RFI

RFI #: 21
 Date: 1/3/2012
 Job: EB-02 Keller Springs Lofts
 Phone: 877-777-5115

CC: Trent Perkins (Parkin Perkins Olsen)
 Subject: Elevation eastside of garage

RFI #: 197
 Date: 10/12/2012
 Job: EB-02 Keller Springs Lofts
 Phone: 877-777-5115

SHEET NUMBER
3.1C
BLDG PLAN 'C'

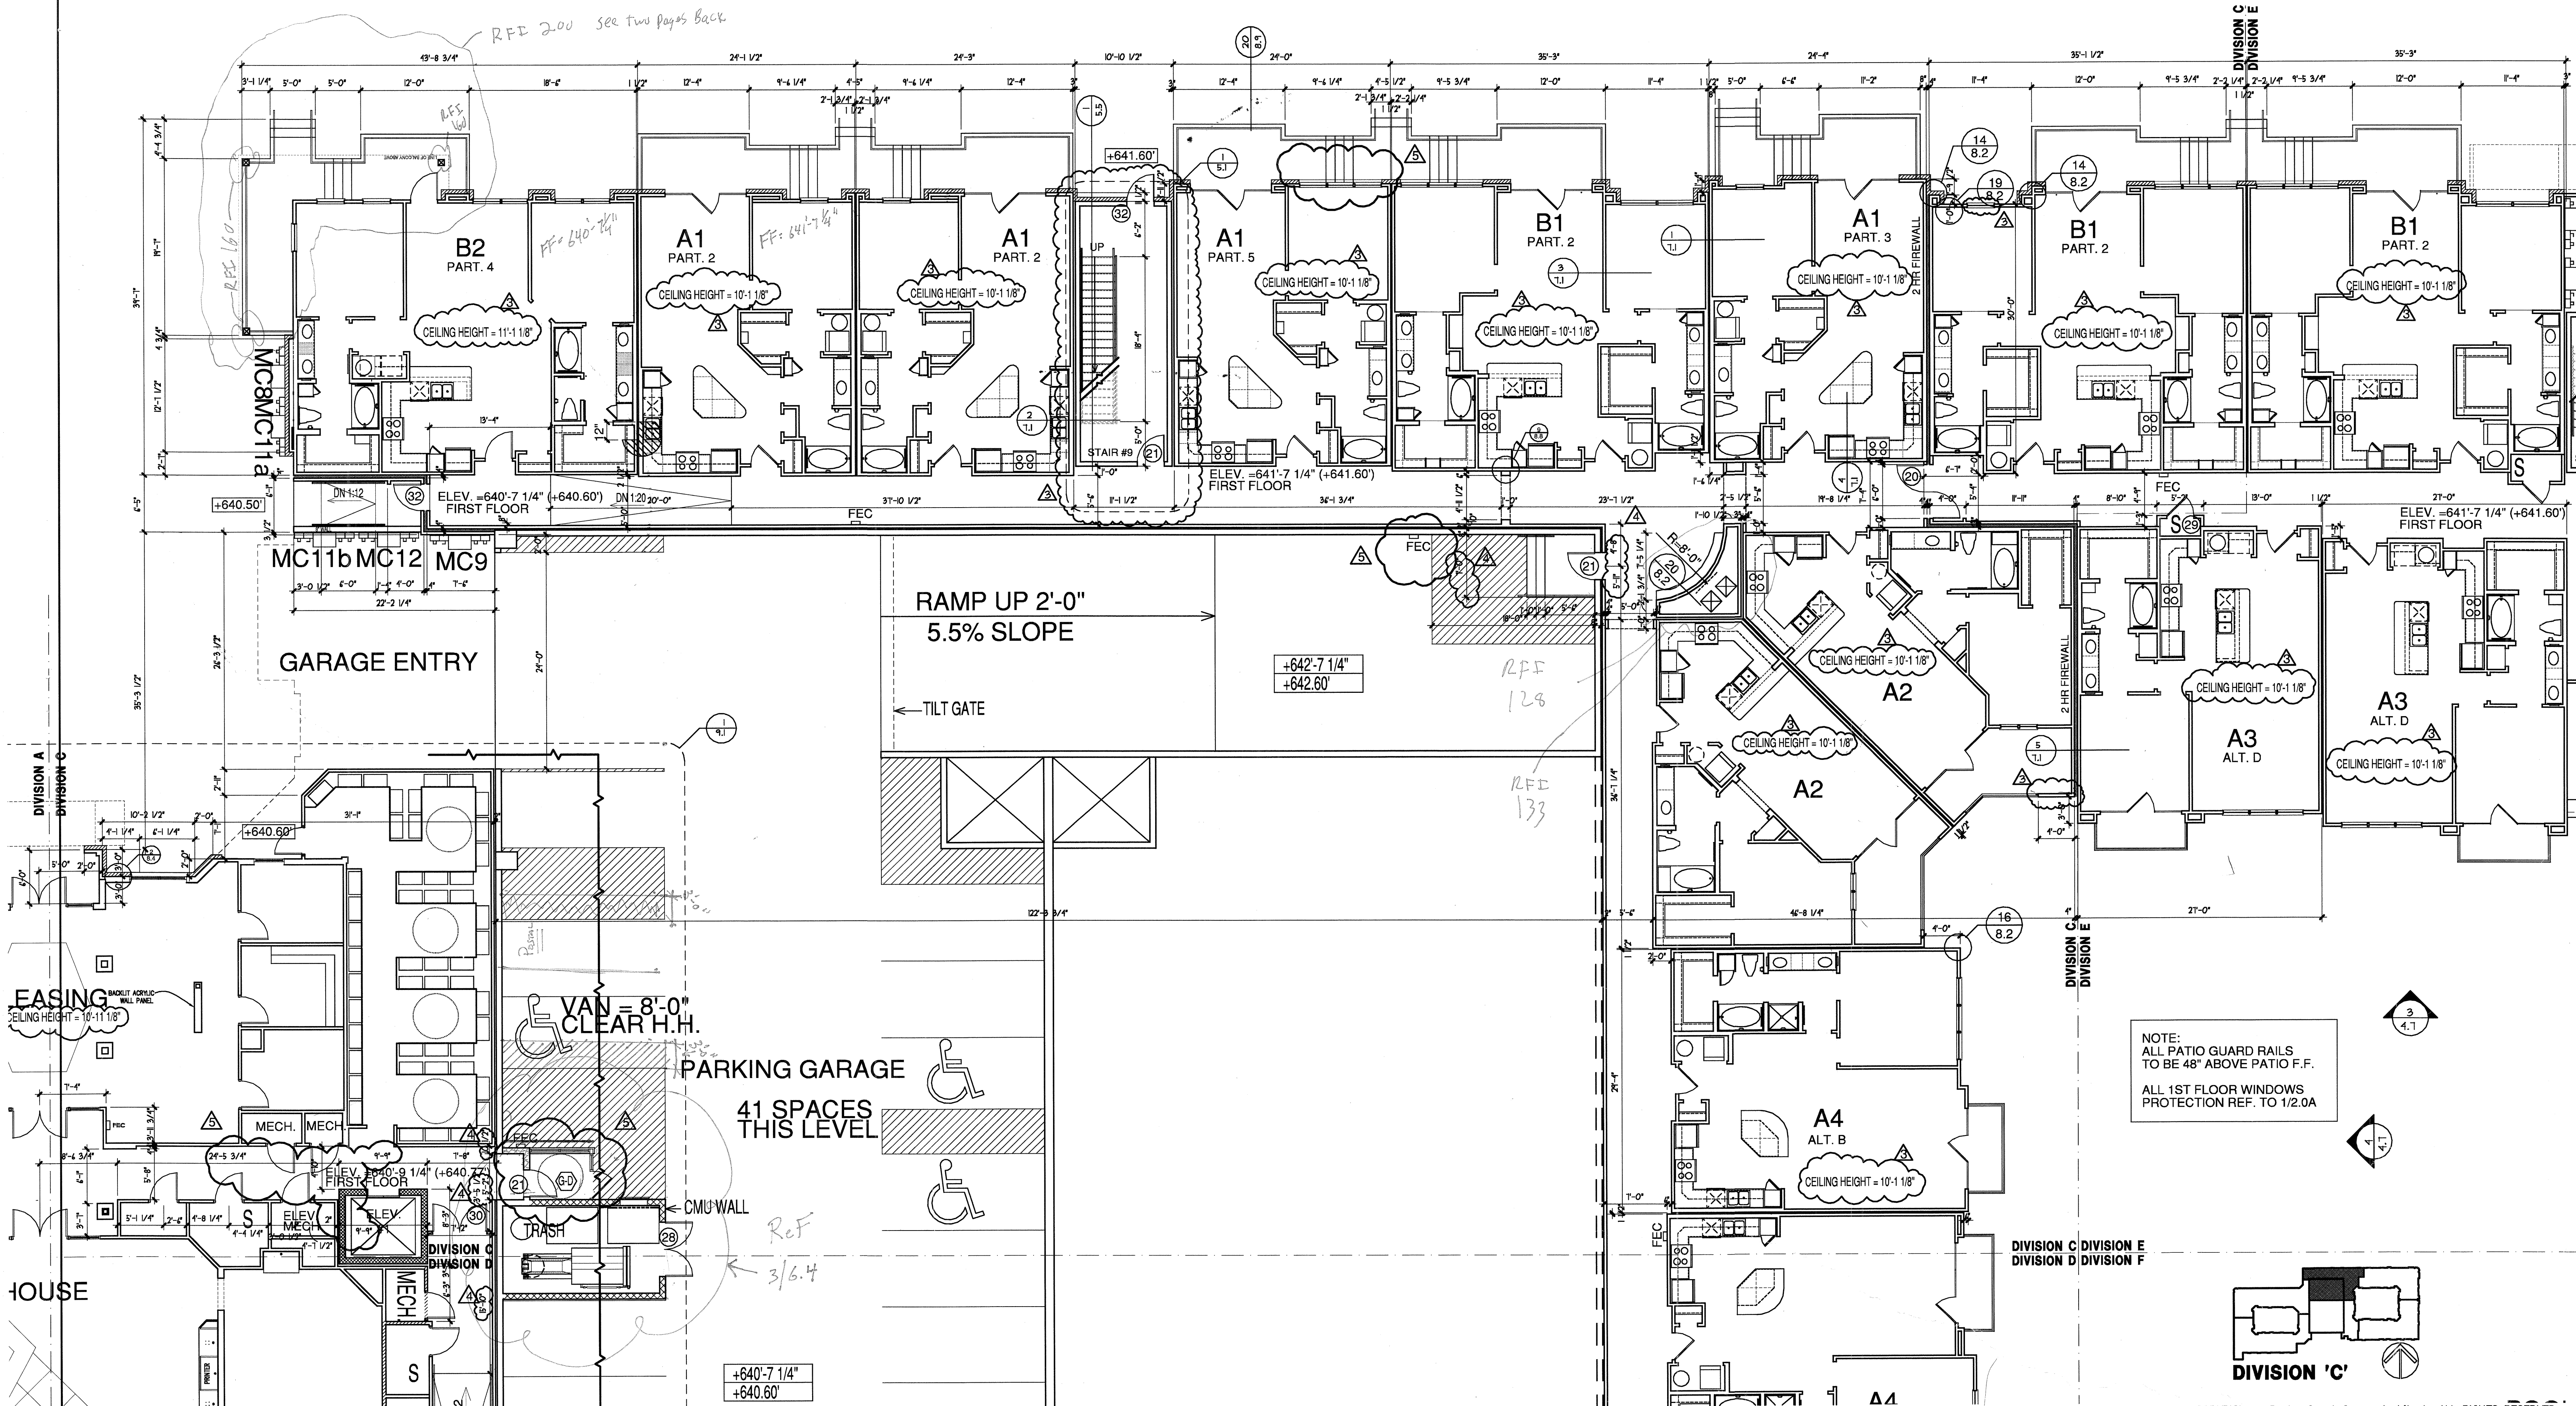
Request: Sheet 3.1D shows elevation 641'-1 1/4" at the corridor of the building on the eastside of garage near A4 at G. unit and ramp. Shouldn't the elevation be 641'-7 1/4" ?
 Date Required: 1/10/2012

Response:
 Correct 641'-7 1/4" as this part of the corridor on sheet 3.1C
